**KIRKLEES METROPOLITAN COUNCIL  
INVESTMENT & REGENERATION SERVICE**

Reference No:	<b>2023/44/93236/W</b>
Site Address:	Pentlands, New Mill Road, Holmfirth, HD9 7LN
Description:	Discharge of conditions 4 (internal estate road details), 5 (parking bay surfacing and drainage), 9 (temporary waste measures), 11 (surface water drainage details), 12 (overflow event scenario), 13 (separate drainage), 15 (temporary drainage measures), 22 (ecological enhancement plan) of previous permission 2020/91896 for demolition of existing dwelling and erection of 15 dwellings with associated access and external works
Recommending Officer:	William Simcock

## Officer Report 2023/93236

### Pentlands, New Mill Road, Holmfirth HD9 7LN

Site Entrance Visibility Splay (2.4m x 70m)
(SCALE 1:250)

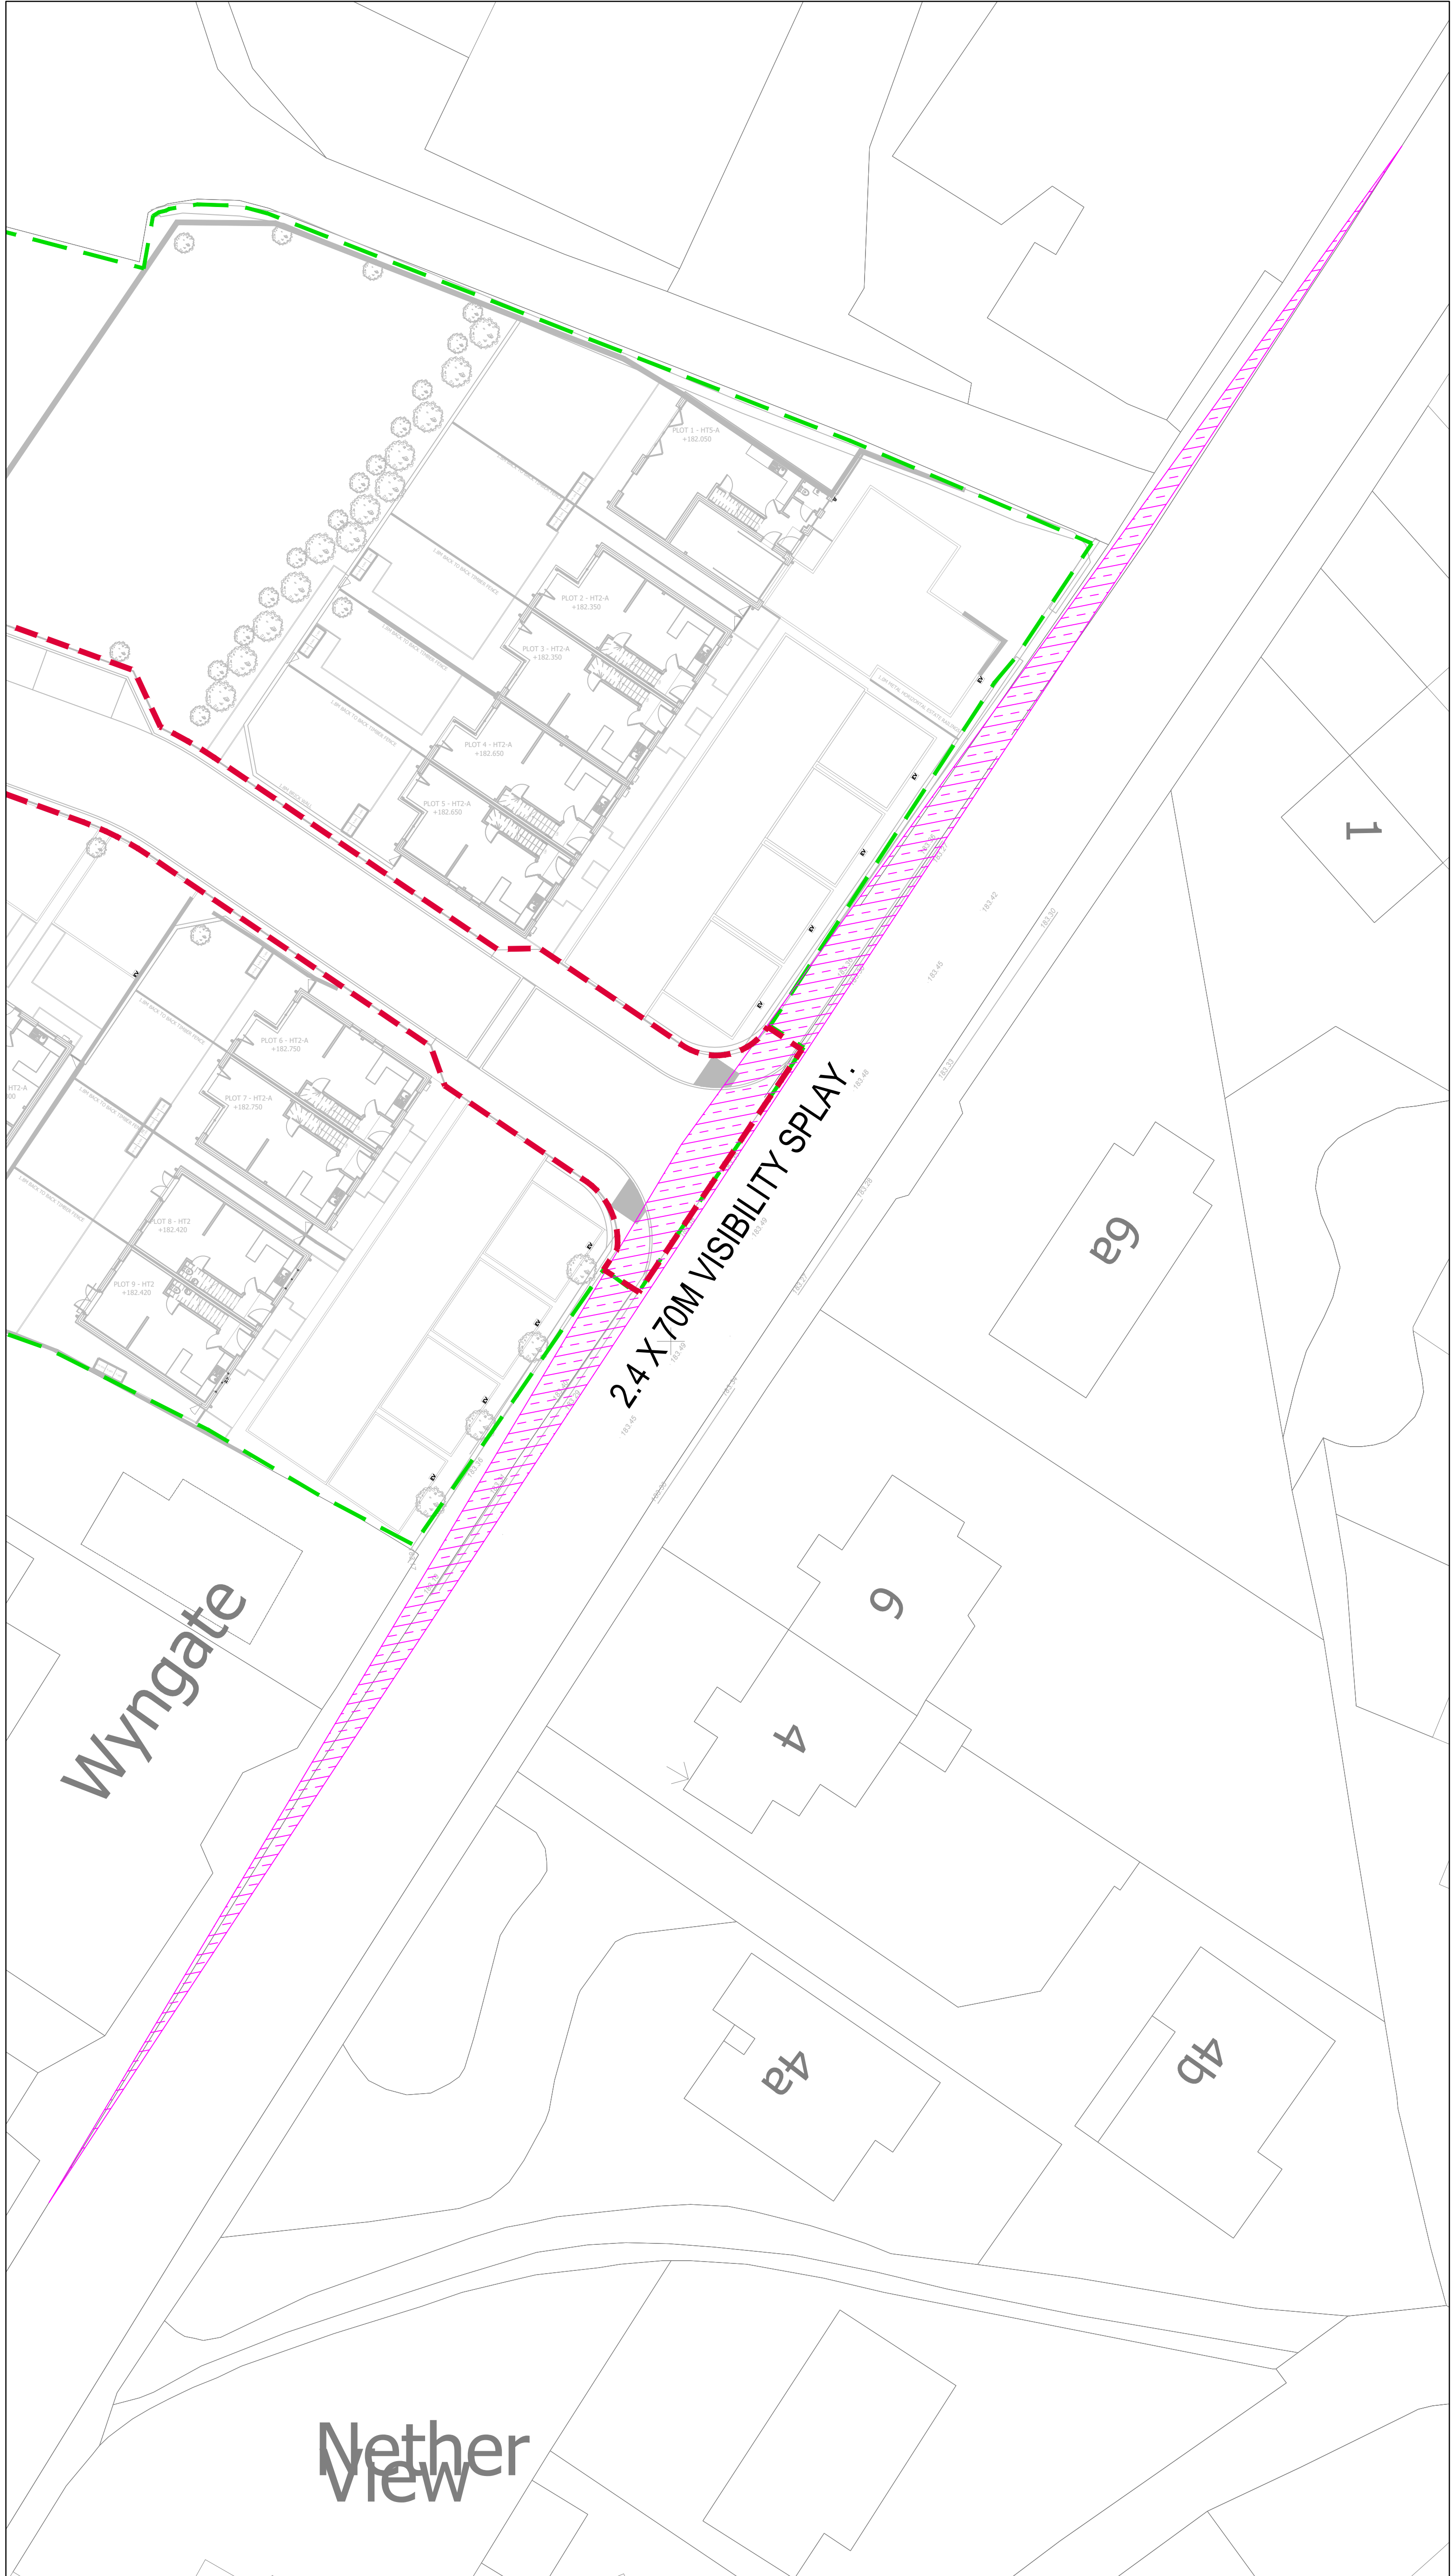
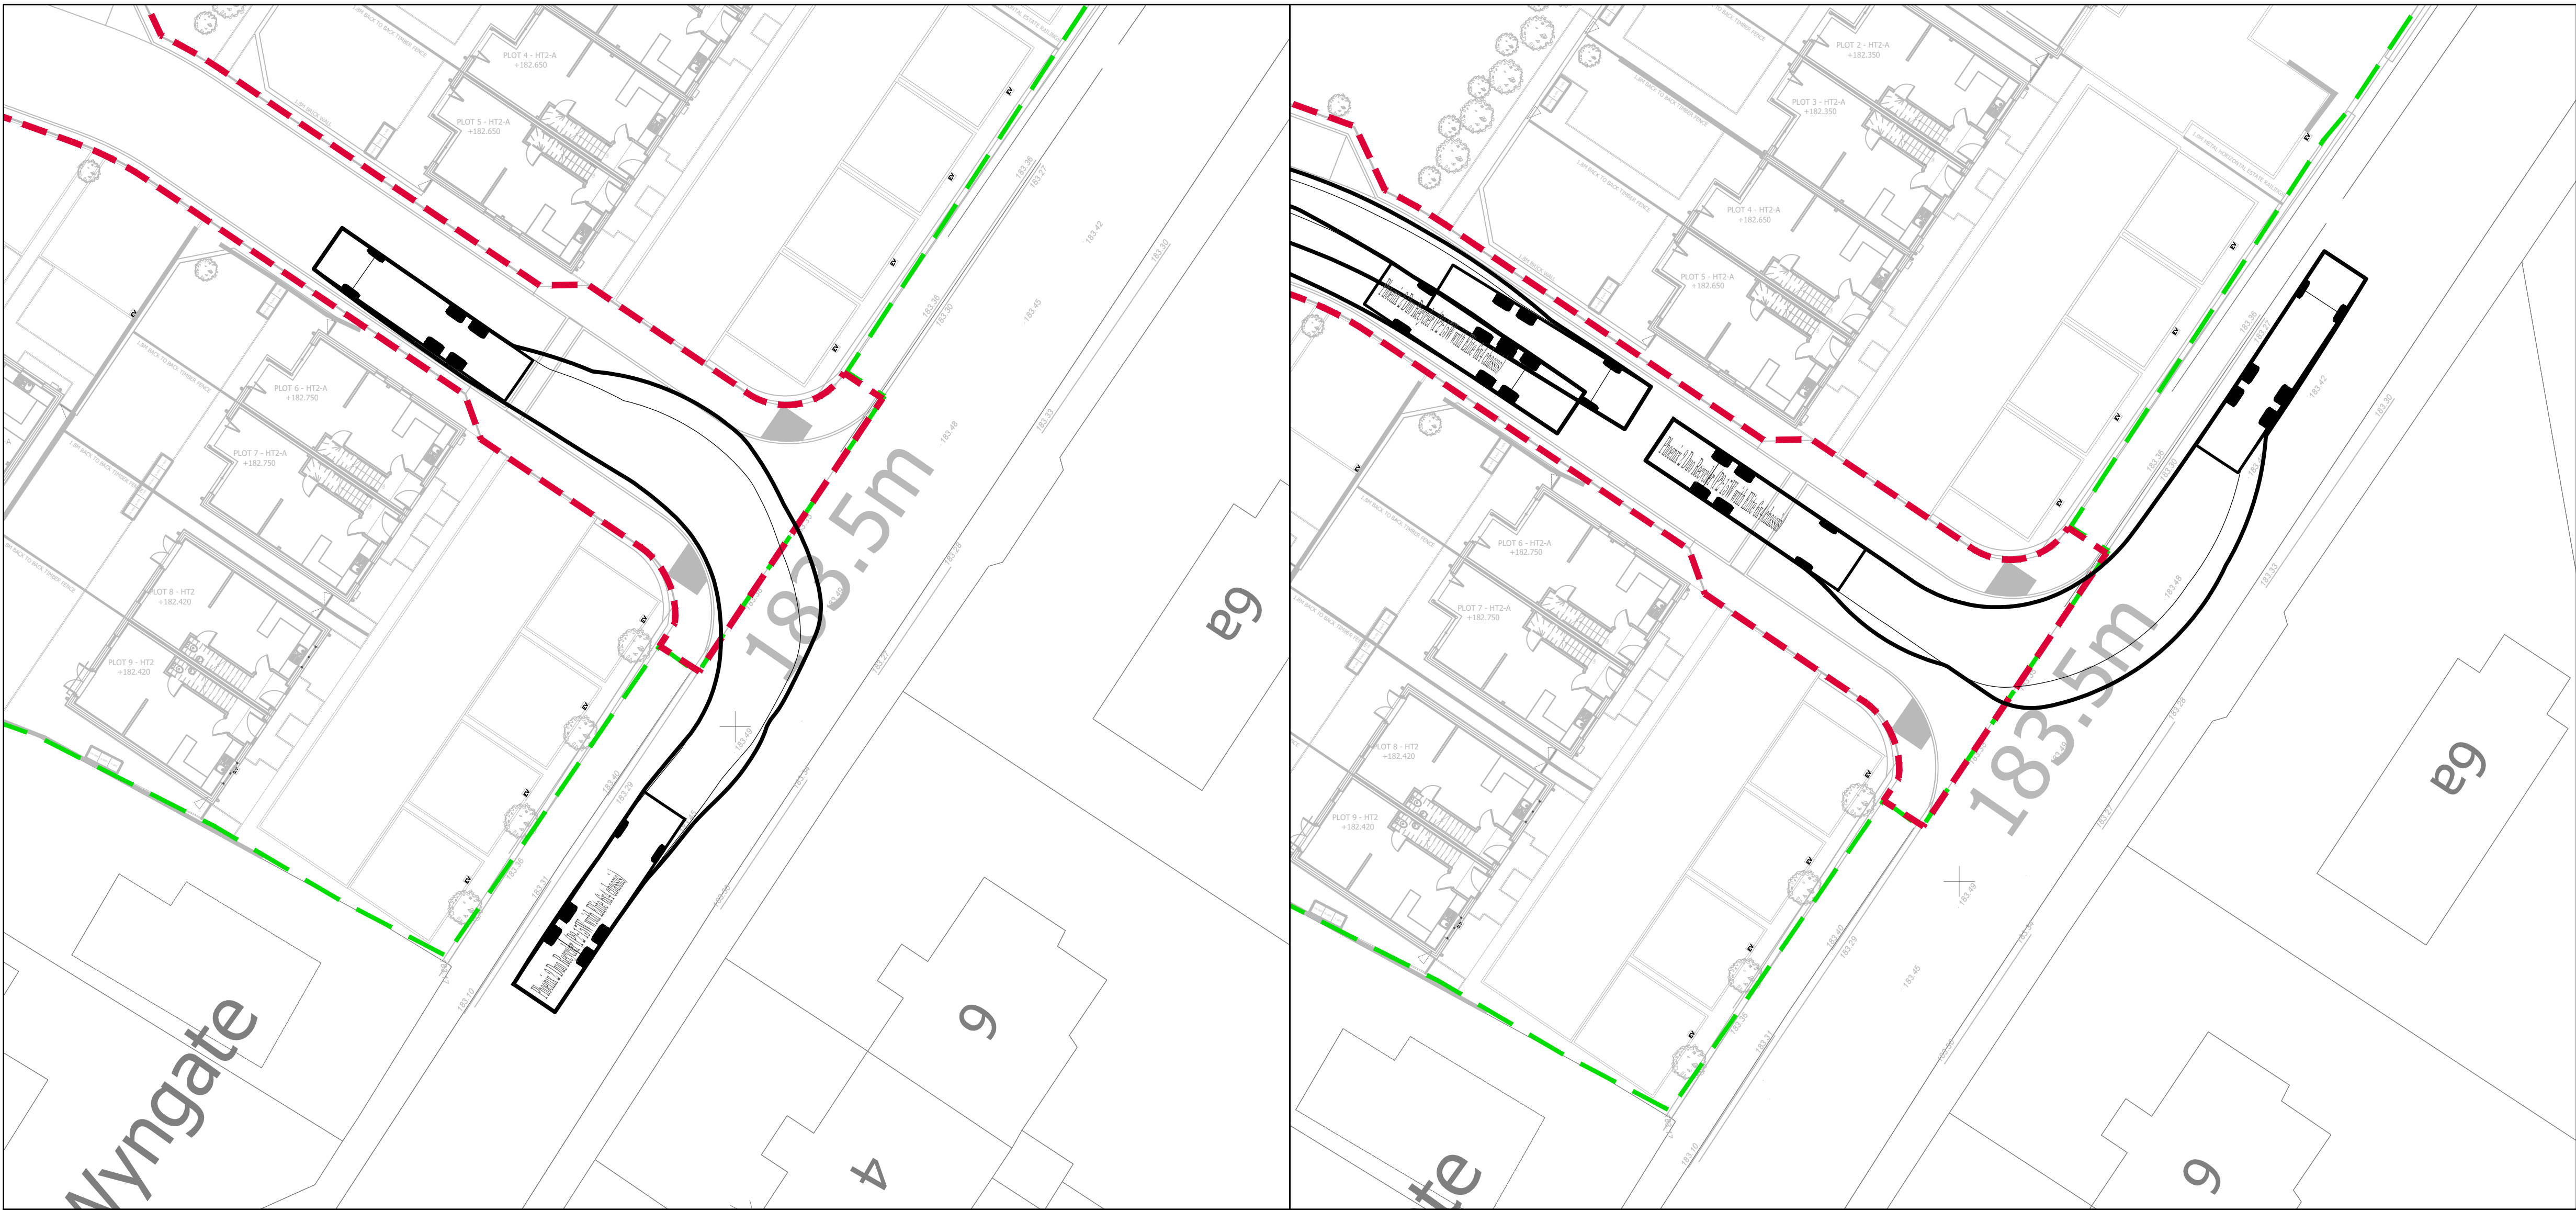
KC Highways Development Management have informed the case officer that these proposals will require a separate formal Technical Approval by the Council's Highways Section 38 Team. The council's section 38 Engineer confirms that technical approval has been applied for, but not yet granted, for the proposed section 38 Agreement. This condition cannot therefore be discharged at the present time.
